CHIPPENHAM WITHOUT PARISH COUNCIL

ExQ2 STATEMENT 04.08.26

LIME DOWN SOLAR PARK – EN010168

Title:
Figure 13-12 Construction Access Locations:
Cable Route Corridor

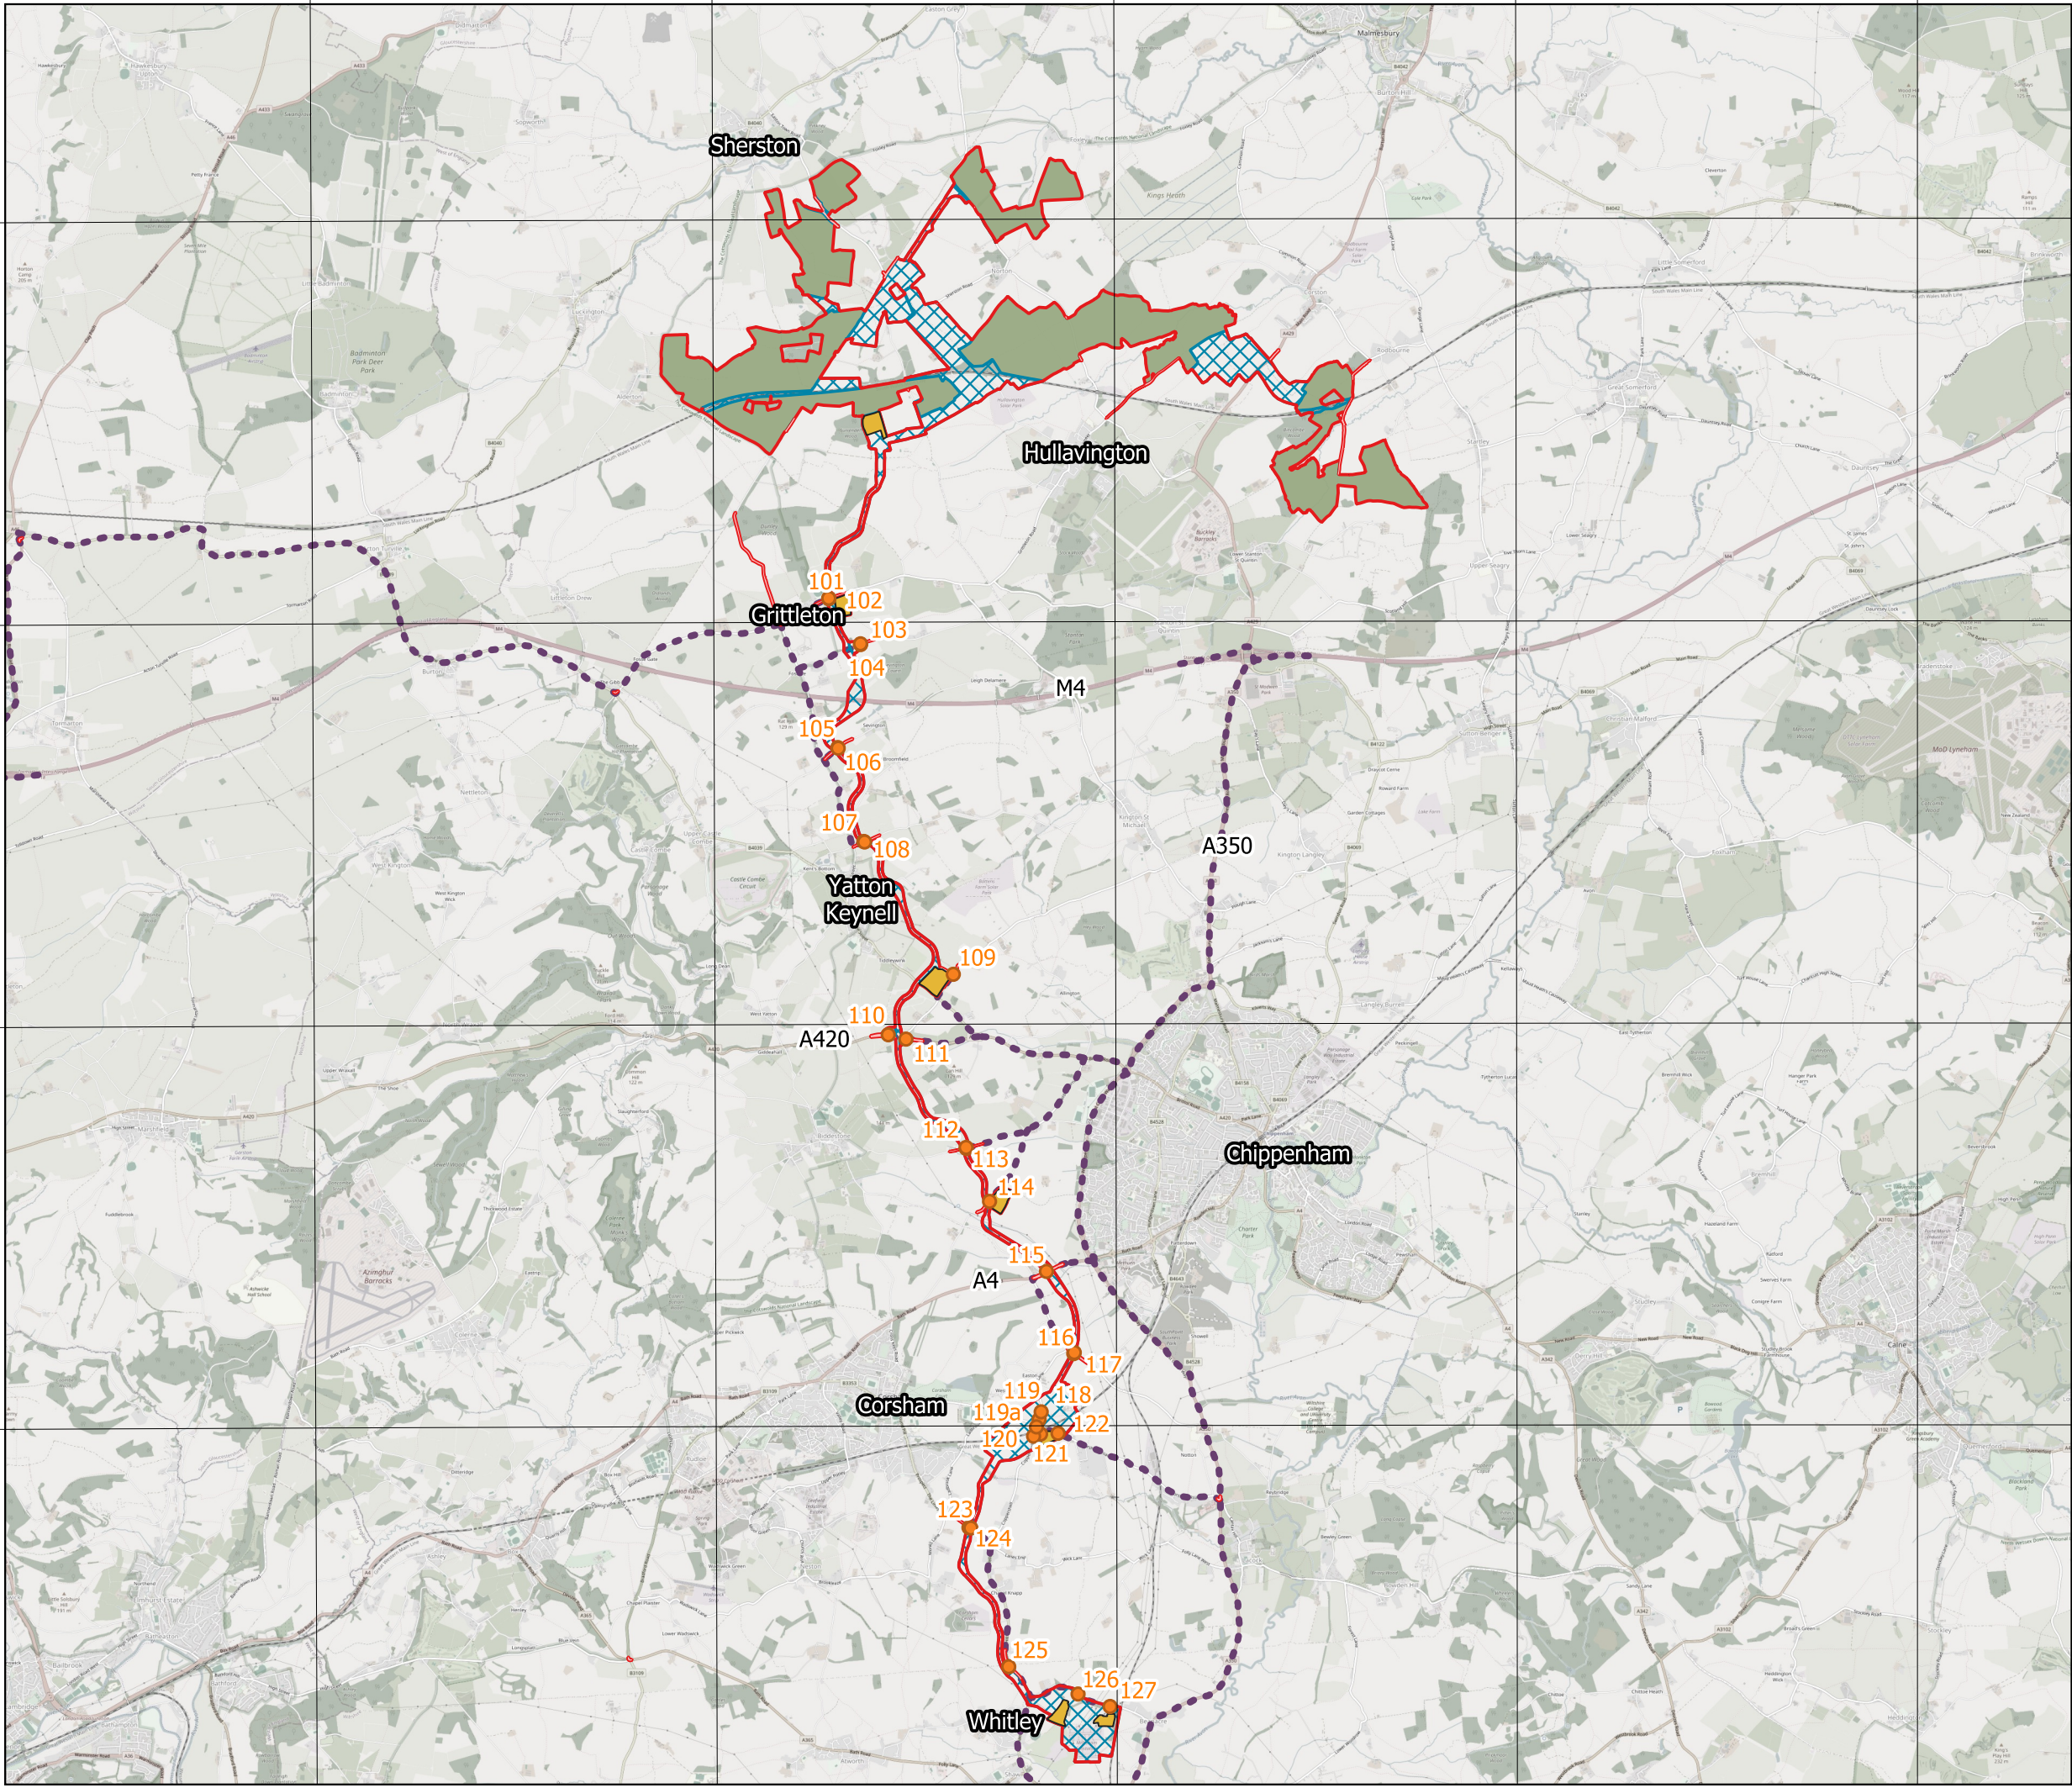
I now respond in connection with this location (highway improvement ref.114 on mapping) and, again, the Council’s original representation covered the arguments/concerns that lead to the Questions that should now be raised.

The applicant has a cable laying construction site in a field to the northwest of Stowell Farm and the crossroads junction (C180/Corsham Lane/Biddestone Lane/Jubilee Wood Road) that marks the boundary of Chippenham Without Parish and Corsham Parish. The access route to this site, as proposed by the applicant, will be from the A420 crossroads further to the north at the junction with the C180 (Allington Bar Farm), along the C180 to Sheldon Corner and then along the C180 in the direction of Corsham. The C180 is, therefore, the main access route from the Class A highway network.

Access to this construction site will be from the C180 via an entrance located on the frontage of a field (highway improvement ref.114 on mapping). The speed limit on this road is unrestricted albeit that some road users acknowledge the narrow road conditions.

Accordingly, construction vehicles, including large (AIL) vehicles, exiting from the site will be doing so with little visibility.

a. The suitability of the C180/A420 crossroads junction as the major access point for construction vehicles, in particular vehicles with an abnormal indivisible load (AIL). This crossroads on the Allington Farm Shop side generally has stationary traffic on the C180 at the A420 junction arising from entry /exit into the Farm Shop and A420 traffic flow. Therefore, is the C180/A420 a safe entry and exit point for construction traffic in the light of current traffic volumes, speed of traffic on the A420 approaching this junction, and the width of the C180 of the Farm Shop side of the junction?

b. Use of the C180 by large vehicles is currently very limited, and largely confined to vehicles visiting Sheldon Corner Trading Estate. Therefore, the (EA) should ask the applicant to demonstrate that the C180 from the A420 to Stowell Farm is of adequate width_for its traffic, and whether there are any potential_hazards for general traffic encountering construction traffic, particularly AIL vehicles, along this route?

c. As described above, the entry/exit onto the C180 of the construction site is blind when approached from directions, and already requires to be approached with caution regarding speed and visibility. Therefore, the Council asks the (EA) why the applicant is not being questioned as to the suitability of this entry/exit position for the construction site?

d. The (EA) should ask the applicant whether AIL vehicles can travel/enter/exit the construction site without having to occupy the whole of the C180 in order to gain a sufficient width and angle of travel/entry/exit i.e. will vehicles approaching find their side to the C180 occupied by a large (AIL vehicle)?

e. The (EA) should ask the applicant whether any hedges or trees need to be removed at the site entry/exit point to ensure safe passage in and out for site traffic, and to safeguard other road users? Also, whether the entrance needs to have a hard surface (metalled)?

APFP Regulation: APFP Regulation: 5(2)(a)
Application Doc no.: APP /6.2
Drawing no.: Figure 13-11

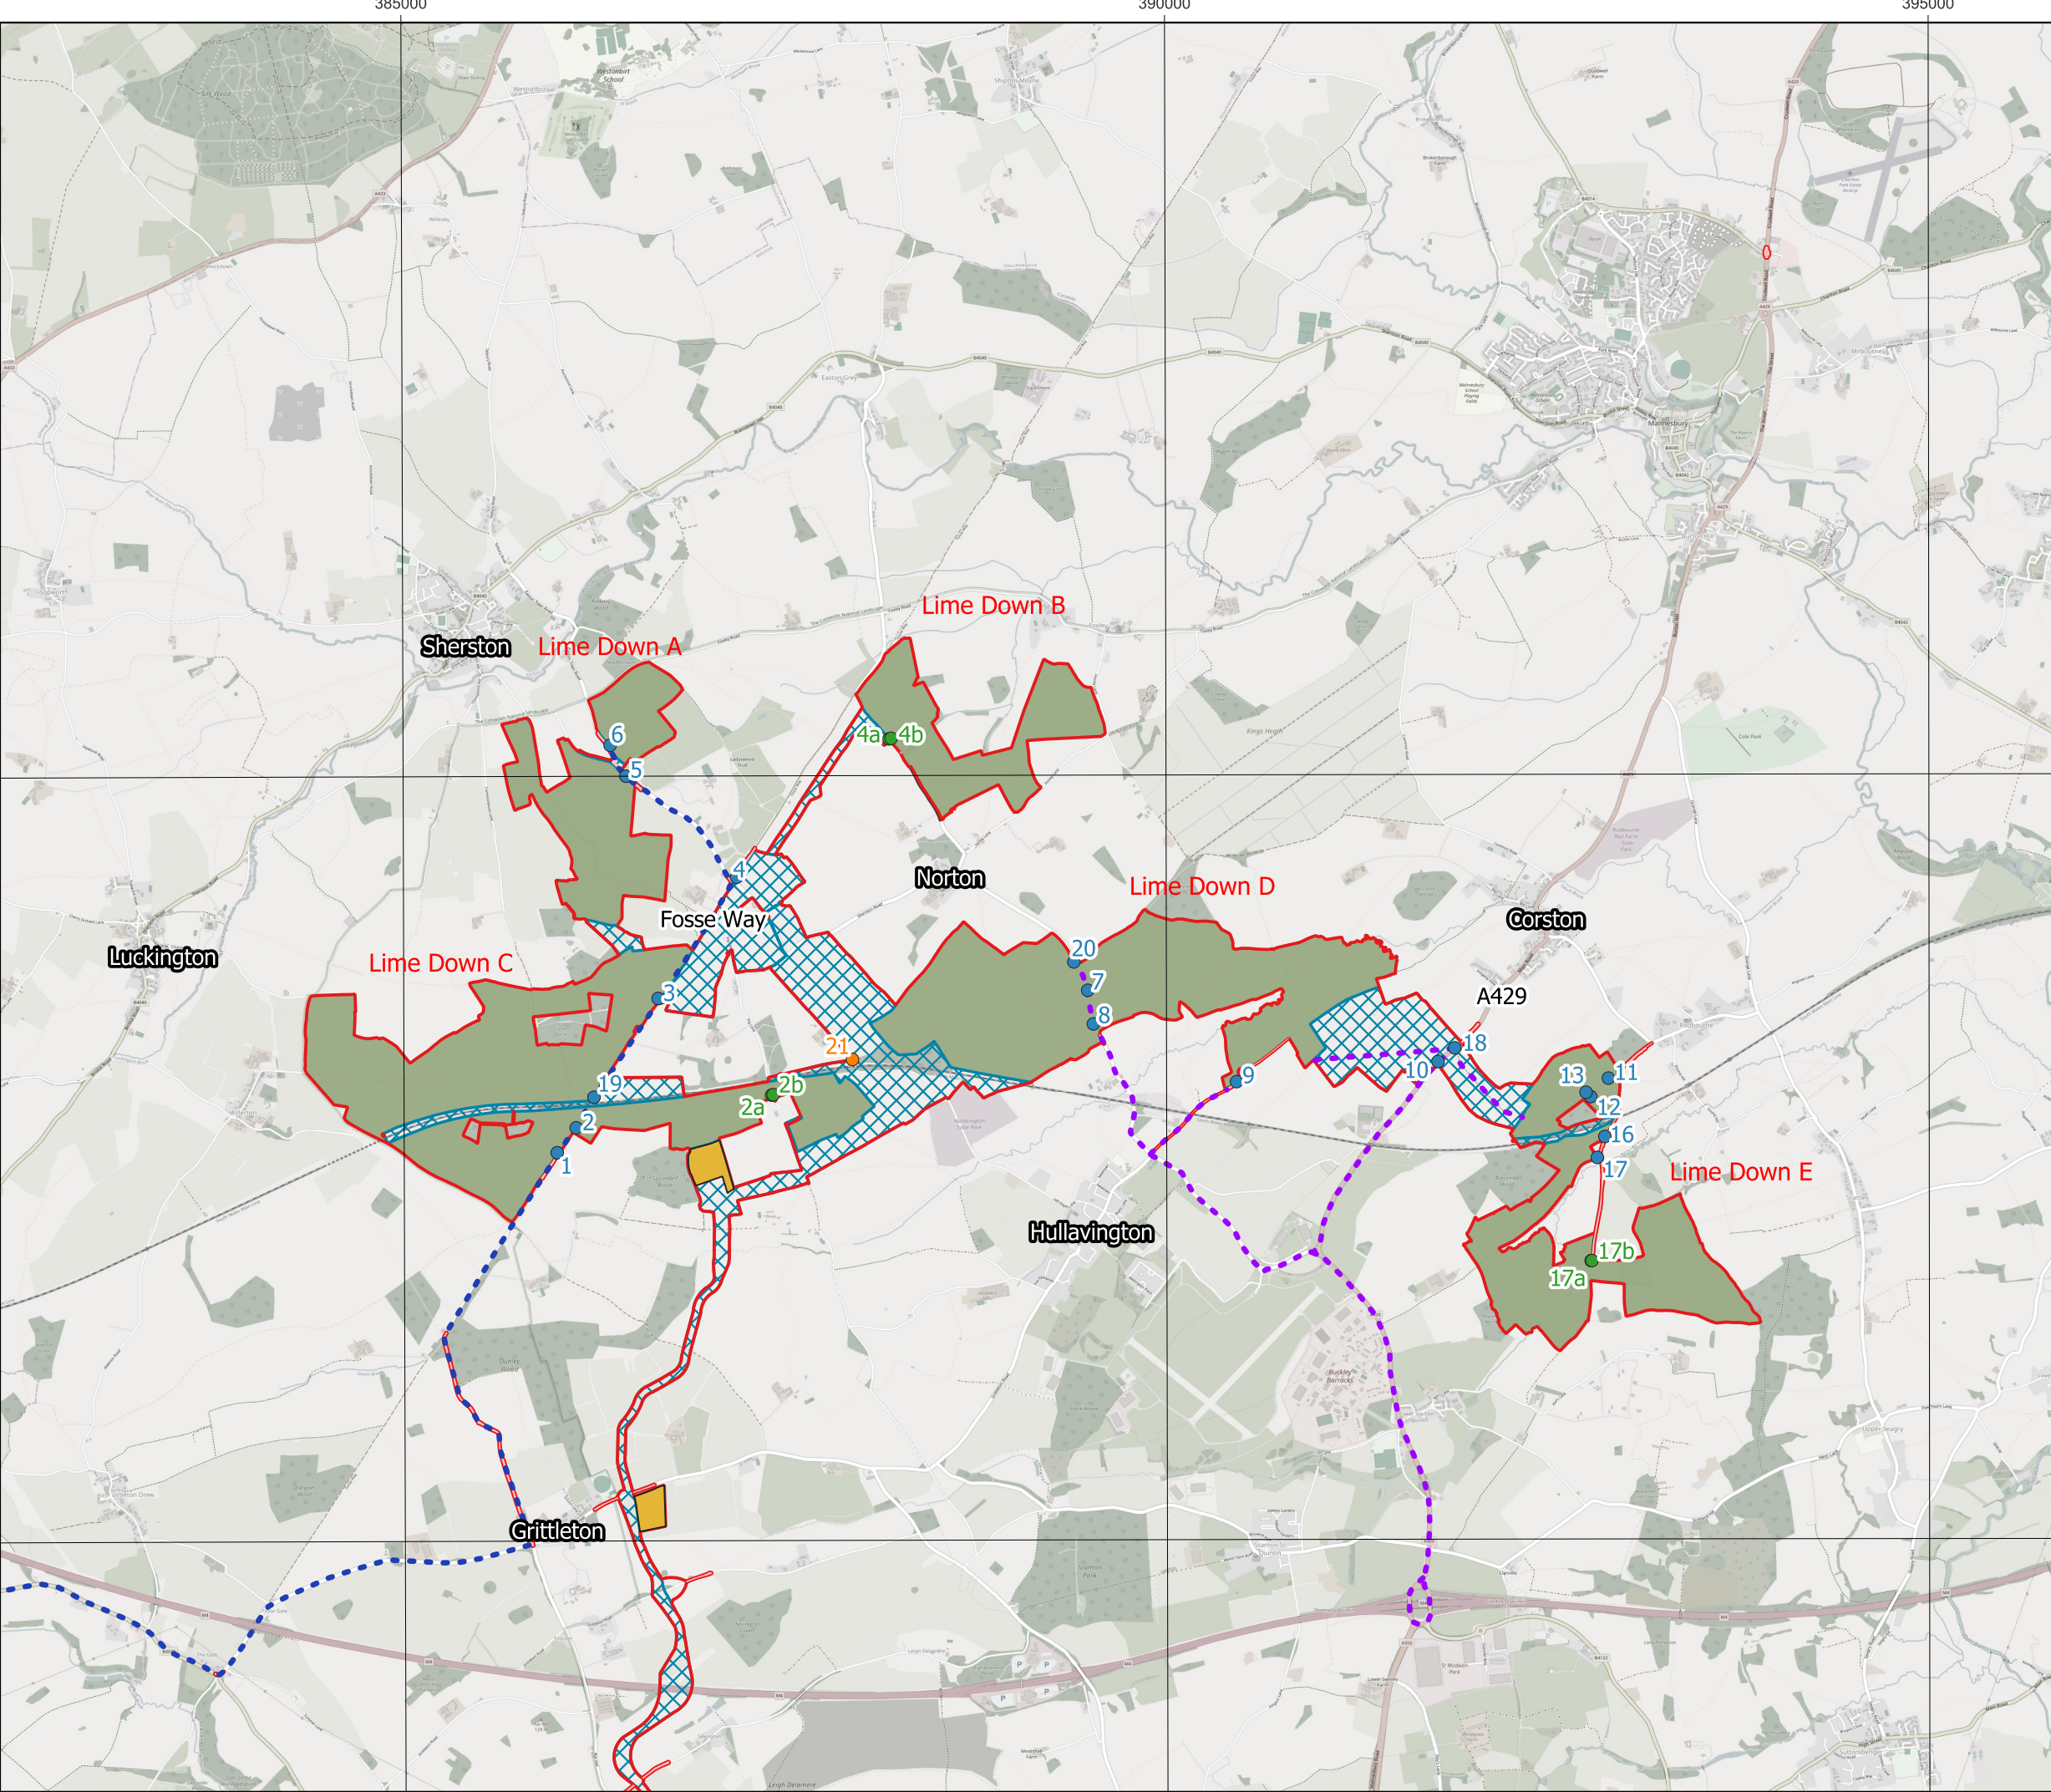
The applicant, as the Examination Authority (EA) observes, is proposing access to the construction site via the track alongside the field to the field's northeast corner. This entrance is near Fowlswick Cottages (highway improvement ref. 109 on mapping).

In the applicant's proposal, this will require "widening" of Fowlswick Lane as far as Fowlswick Farm in one direction and part way along Fowlswick Lane in the direction of the B4039, but not all the way up to the junction with the B4039. However, this length will also require improvement in road quality on the Lane and, also, the track leading to access into the site. It will also require removal of hedges.

- a. The remainder of Fowlswick Lane to the junction with the B4039 will also require improvement (upgrading) similar to that stated. Why is this section of Fowlswick Lane not included and therefore not part of the (EA) questioning of the applicant?

- b. The applicant's exit proposal from Fowlswick Lane onto the B4039 is subject to very limited visibility, with the speed on the B4039 at this point unrestricted. Therefore, there is a significant visibility hazard for Abnormal Indivisible Load (AIL) vehicles exiting the Lane at this point, and a hazard for vehicles approaching this junction from Yatton Keynell direction. To improve visibility, hedges will have to be removed on the B4039, and vehicles speeds on this section of the B4039 will have to be restricted. Therefore, why are these matters not included and part of the (EA) questioning of the applicant?

- c. If the applicant advises the (EA) that it will change the construction site's access to a new entrance on the southwest corner of the field, i.e. essentially at the junction of Fowlswick Lane at the B4039, then questions a. and b. still apply.
